**Review of Environmental Impact Statement  
Western Coal Services Project**

I refer to your recent request for Trade & Investment, Division of Resources and Energy (DRE) to review and provide comments on the proposed Western Coal Services Project Environmental Impact Statement (EIS).

Figure 2 Location of the two haul road and bridge Options

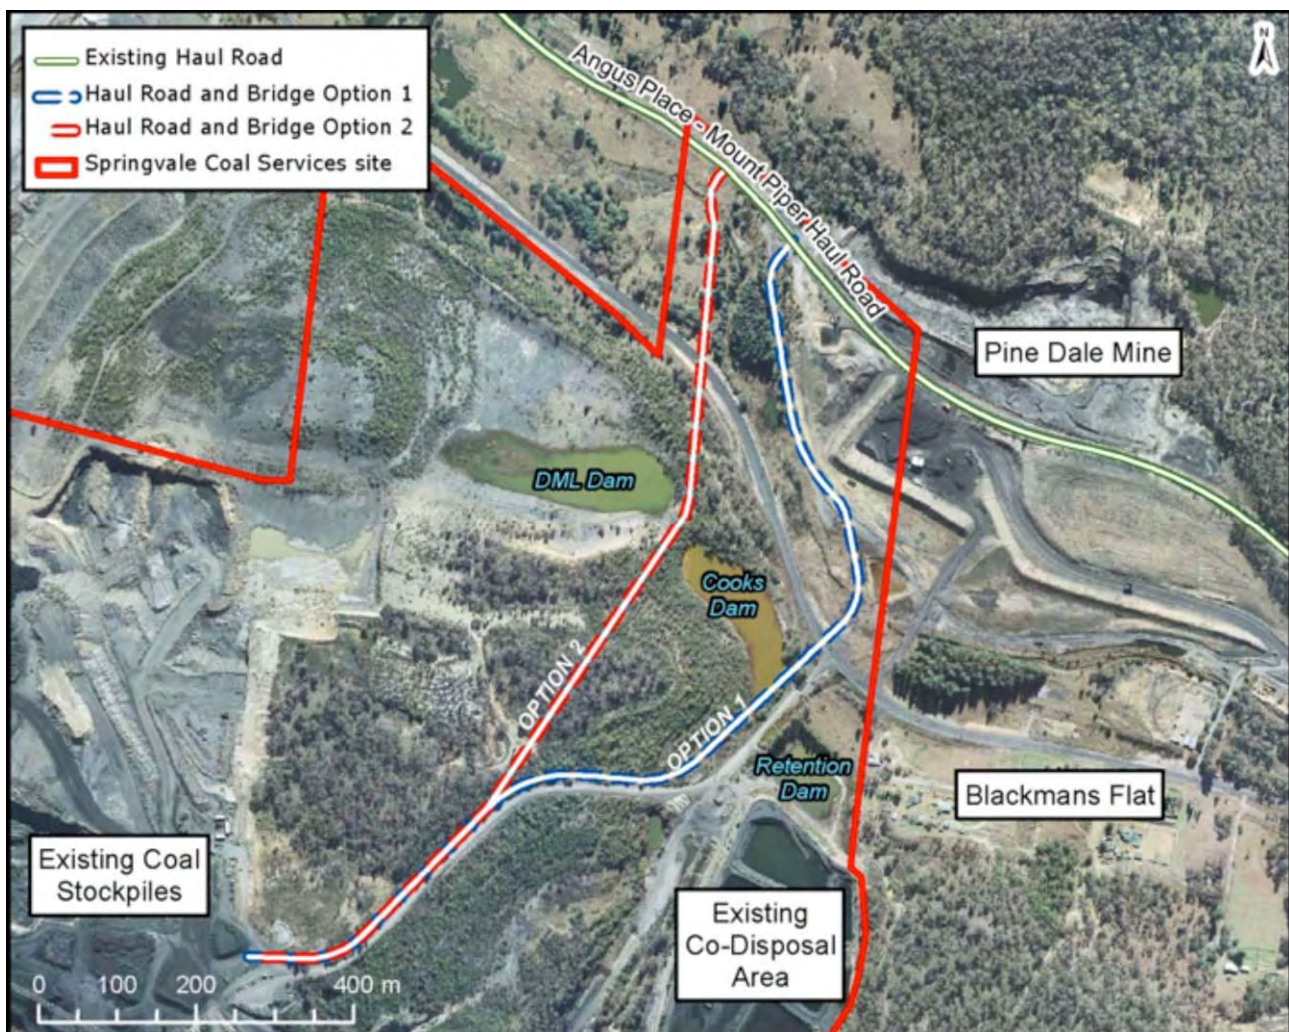
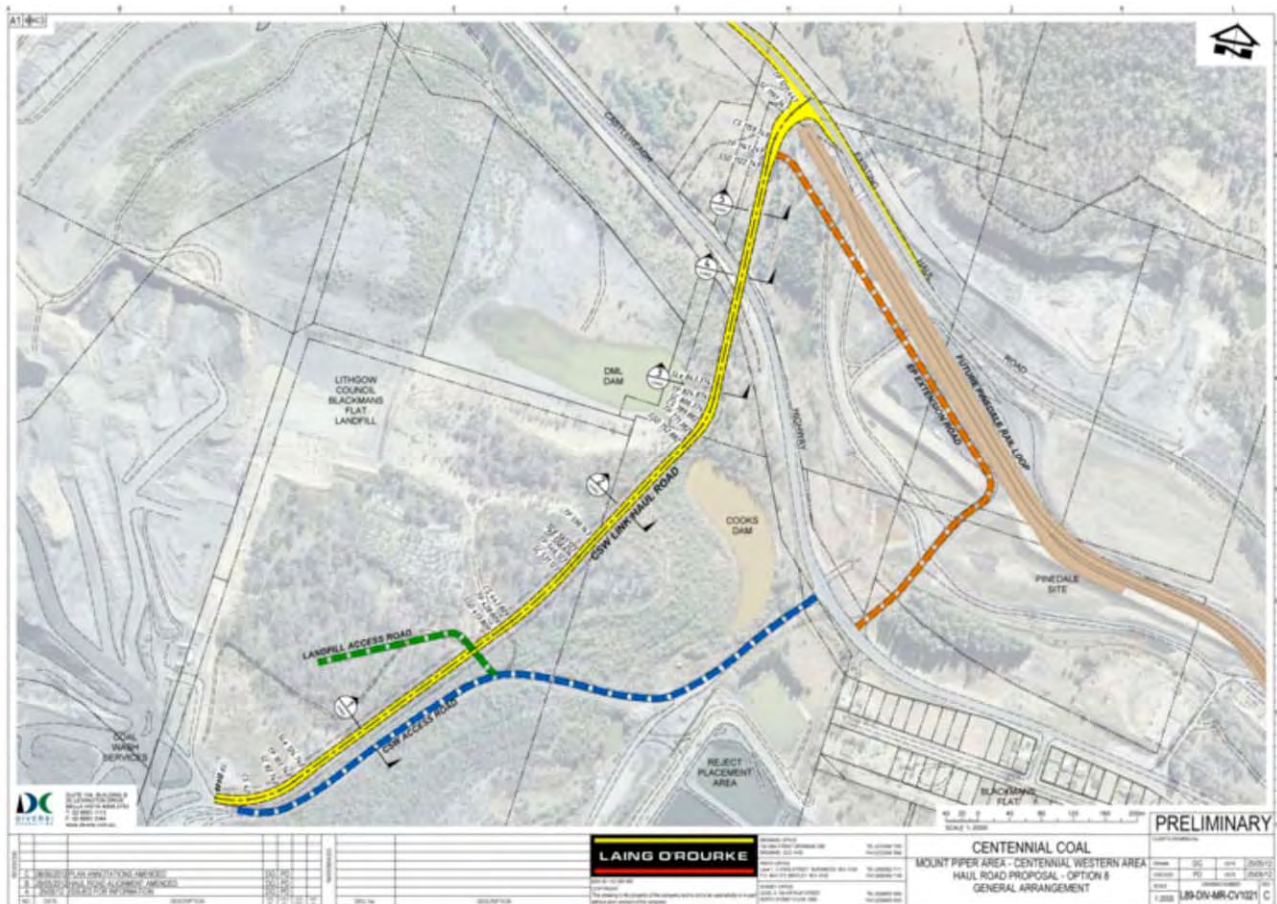
The EIS indicates the new link haul road will be retained as part of the existing road network (Figure 11 and Section 5.5.8) following project completion. This proposal needs to be accepted by another party, including a commitment for ongoing maintenance, otherwise the haul road and bridge should be removed. Unless future responsibility by another party is demonstrated, the removal must be considered and documented in the forthcoming RMP/MOP.

**Figure 5 Depiction of existing ground level and proposed level with the completed REA**

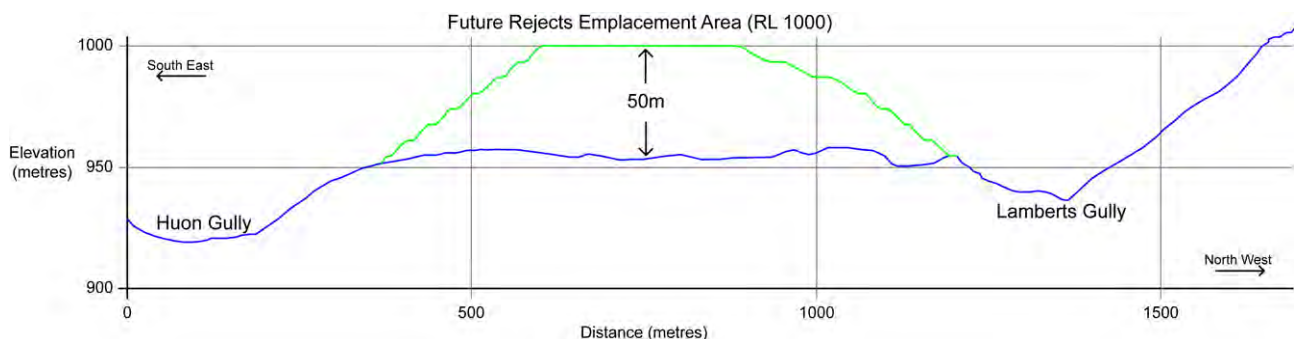
DRE notes that the REA Cross Sections (page 53 of the EIS) show an extensive flat surface. This is not a landscape consistent with the pre-mining landform which is predominantly undulating hills. A more natural landform would be more appropriate for this area. However, it is noted in the visual impact section of the EIS that the flat top, minimising total height, may reduce visual impacts from certain vantage points (page 187). It is recommended that the final landform of the top of the REA be reconsidered in the forthcoming RMP/MOP.
